From: Sue Howell
Sent: 25 June 2015 16:14
To: Planning.Responses
Cc: Simon Davis
Subject: RE: Planning Consultation on: F/7/15/OUT

Comments from Greenspace

APPLICATION F/7/15/OUT
NO:

Description of Works: Outline application for residential development comprising 45 dwellings. Formation of access onto Burndell Road (Resubmission following F/9/14/PL) - This application also lies within the parish of Yapton. This application is a Departure from the Development Plan.

Client: Brookworth Homes		
Scheme: Burndell Road, Yapton		
Drawing: Planning layout		Figure No: 5
Date: March 2015		ACD ref: BRO 19804
Scale: NTS@A3	Drawn: AW	Checked: JPF

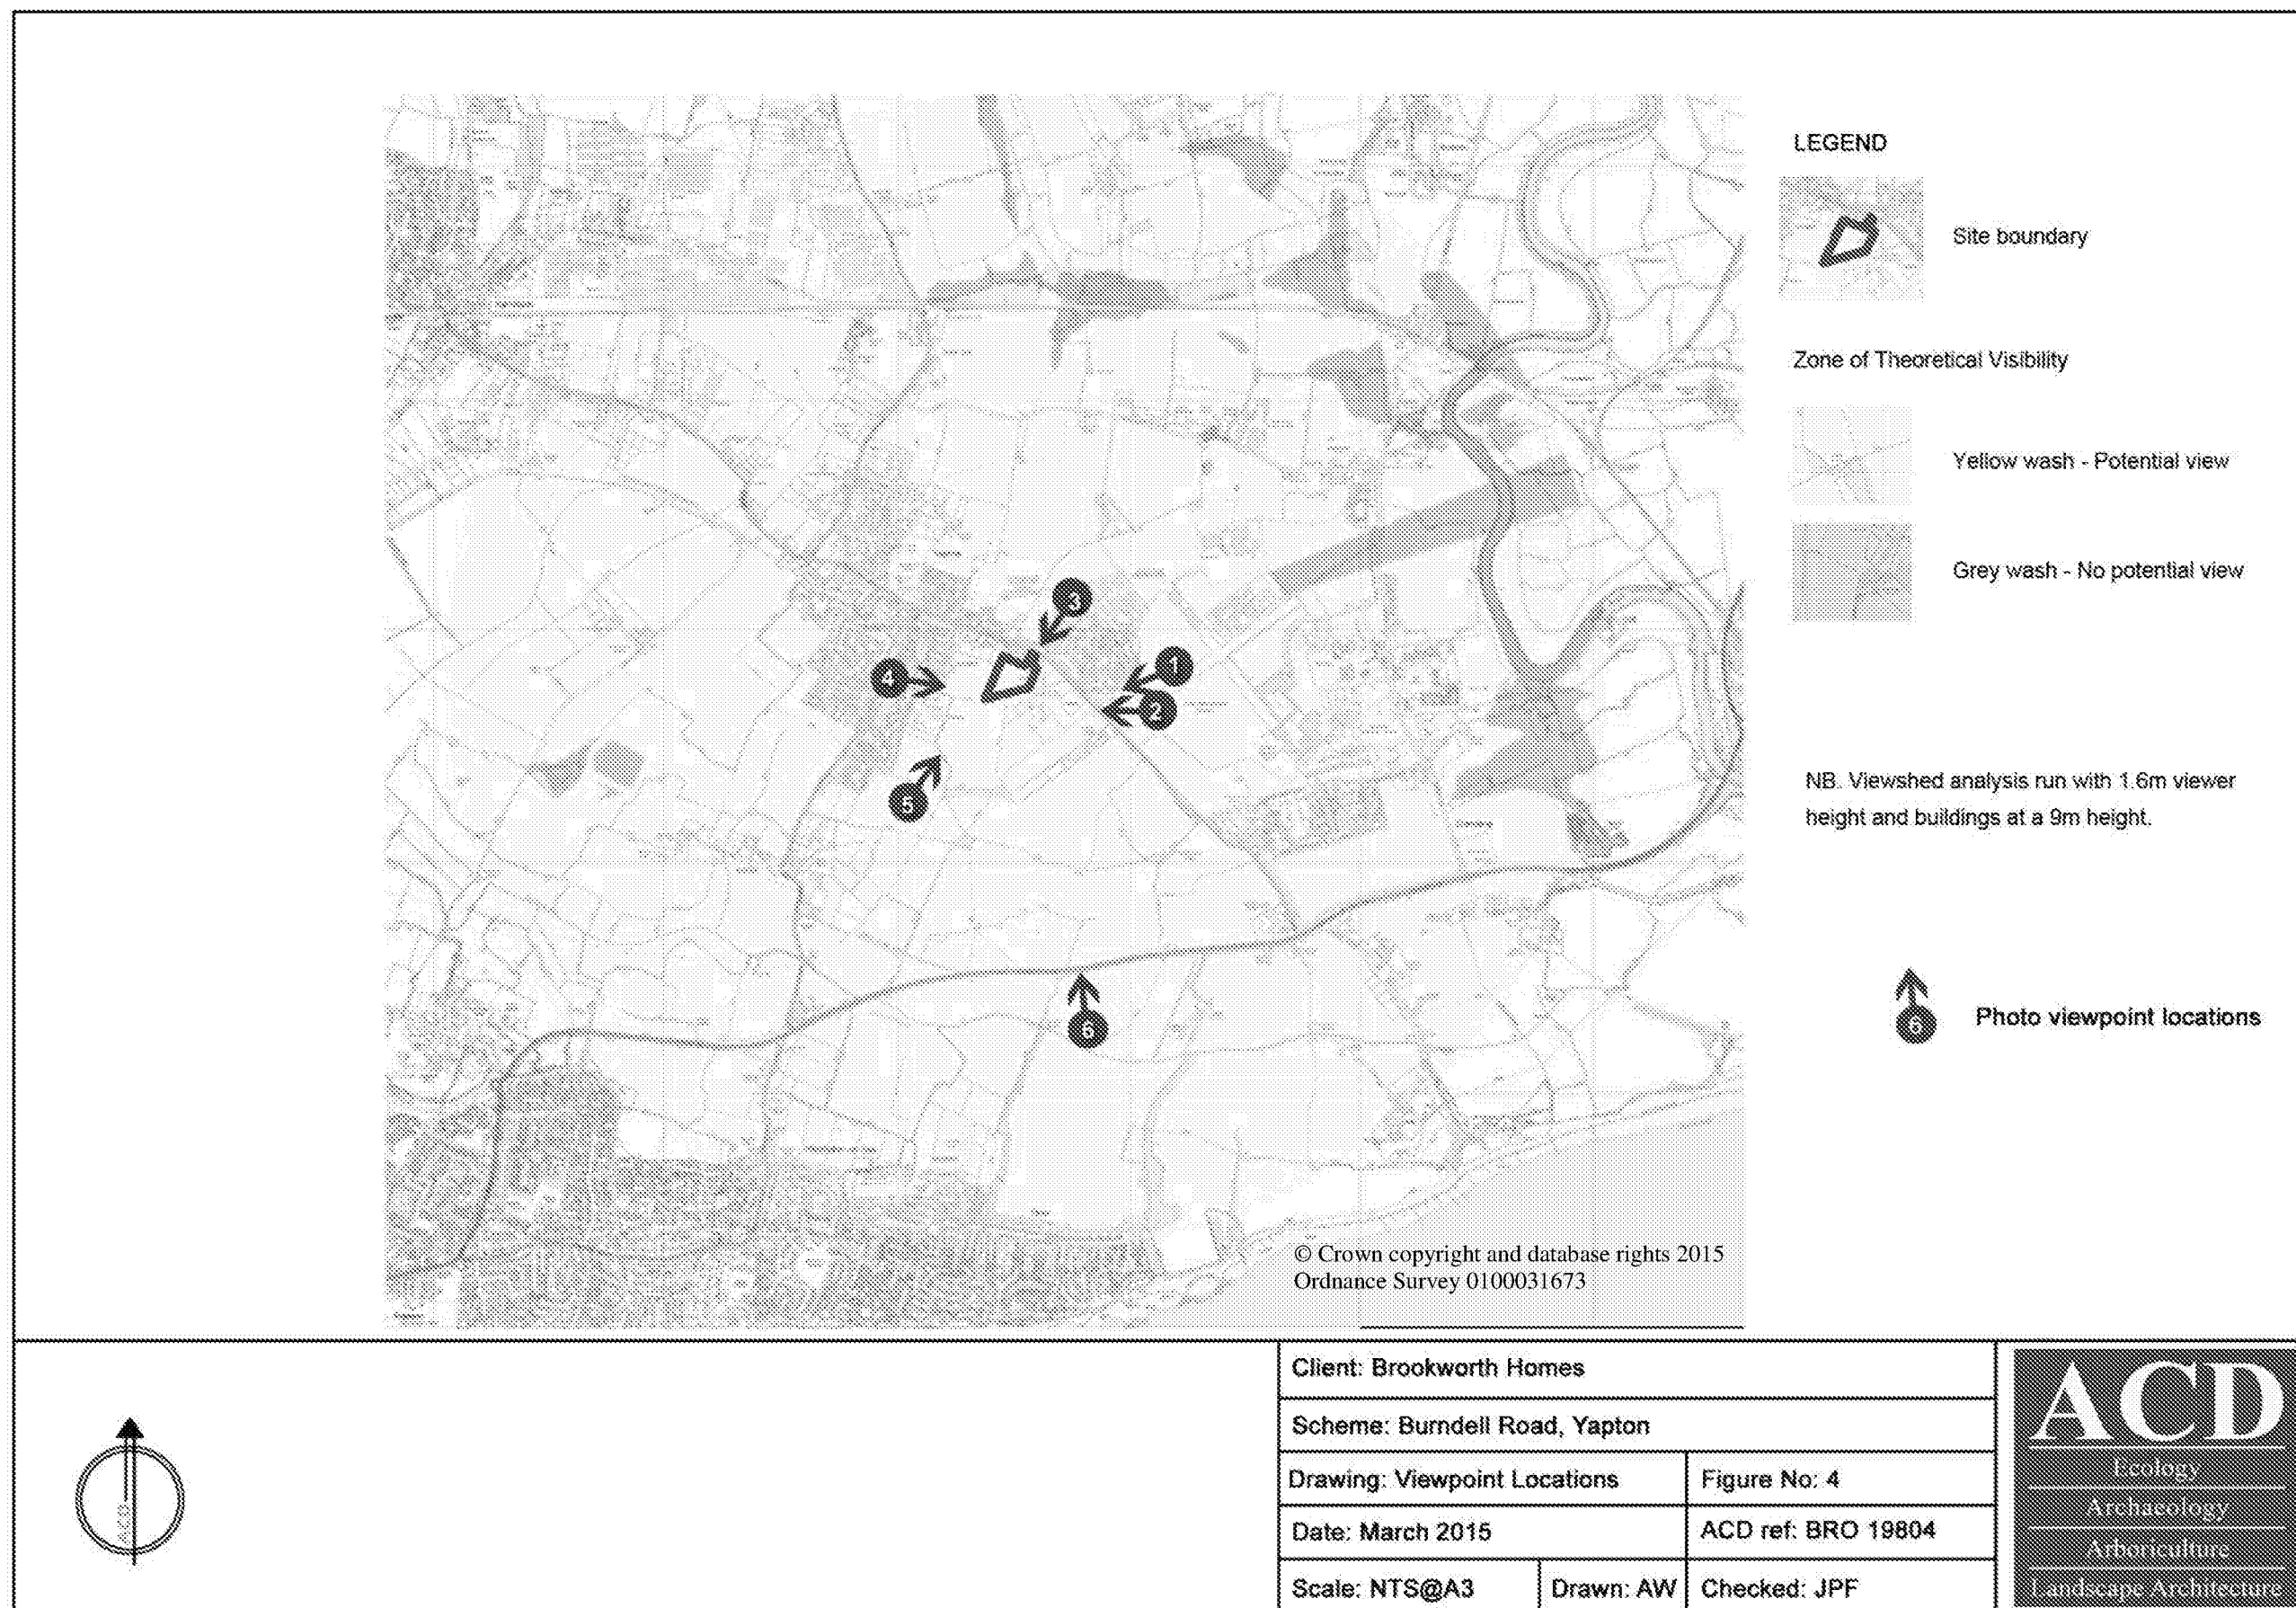
will be achieved will also need to be agreed. The area indicated as 'pond' on the proposed layout would need to be subject to a ROSPA inspection due to the proximity to public open space and pathway areas.
